SEA LINK

EN020026

Comments on Submissions received by Deadline 2

Suffolk County Council

THE NATIONAL GRID (SEA LINK) ORDER  
 PINS APPLICATION NUMBER: EN020026  
 TREES AND HEDGEROWS TO BE REMOVED OR MANAGED PLANS - SUFFOLK  
 REGULATION 5(2)(o)  
 KEY PLAN 1 OF 1  
 IN THE DISTRICT OF EAST SUFFOLK DISTRICT COUNCIL

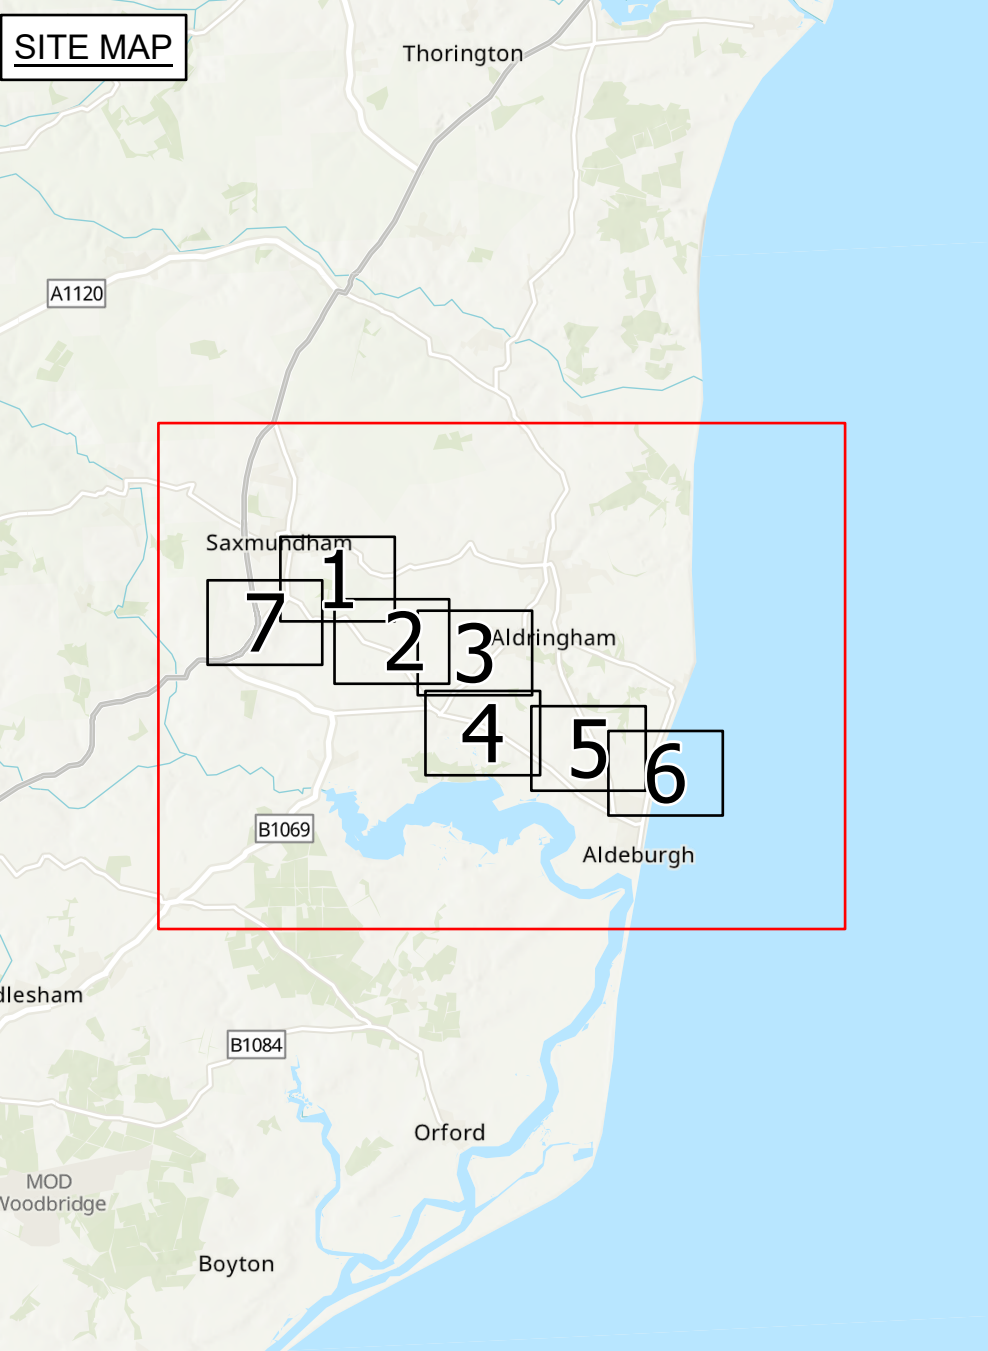
A2.17	Draft Development	The relevant Important Hedgerows are shown on the Trees and Hedgerows to be	SCC does not consider this sufficient and requests that a schedule is included in the

Ref. No	Topic	Summary of submission	SCC Response	Document Ref(s)
	Consent Order (“dDCO”) [AS087] 5.166	Removed or Managed Plans, rather than in a schedule within the draft DCO.	DCO. A schedule in the DCO would be preferable and is precedented for similar projects such as within Schedule 11 of EA2’s DCO. This would avoid confusion and make the DCO more precise as the plans cited by the Applicant do not include hedgerows categorised as non-important.	
A2.18	Document 7.5.3: Outline Onshore Construction Environmental Management Plan (“CEMP”) [AS-127] 5.168-5.174	Adaptive management measures are committed to in the oLEMP, the detail of which will be developed further post determination in the full LEMP	SCC considers that the measures presented in the REAC and CoCP need to align and be cross-referenced with the oLEMP and full LEMP, and that discrepancies need to be addressed.	
A2.19	Management periods 5.158	Five years of aftercare for the reinstatement planting is considered appropriate by the applicant. This planting would be managed for the lifetime of the project.	SCC considers a 5-year aftercare period for woodland features as insufficient. This aftercare period needs to be at least 10-15 years, given the time it takes for trees to reach maturity.
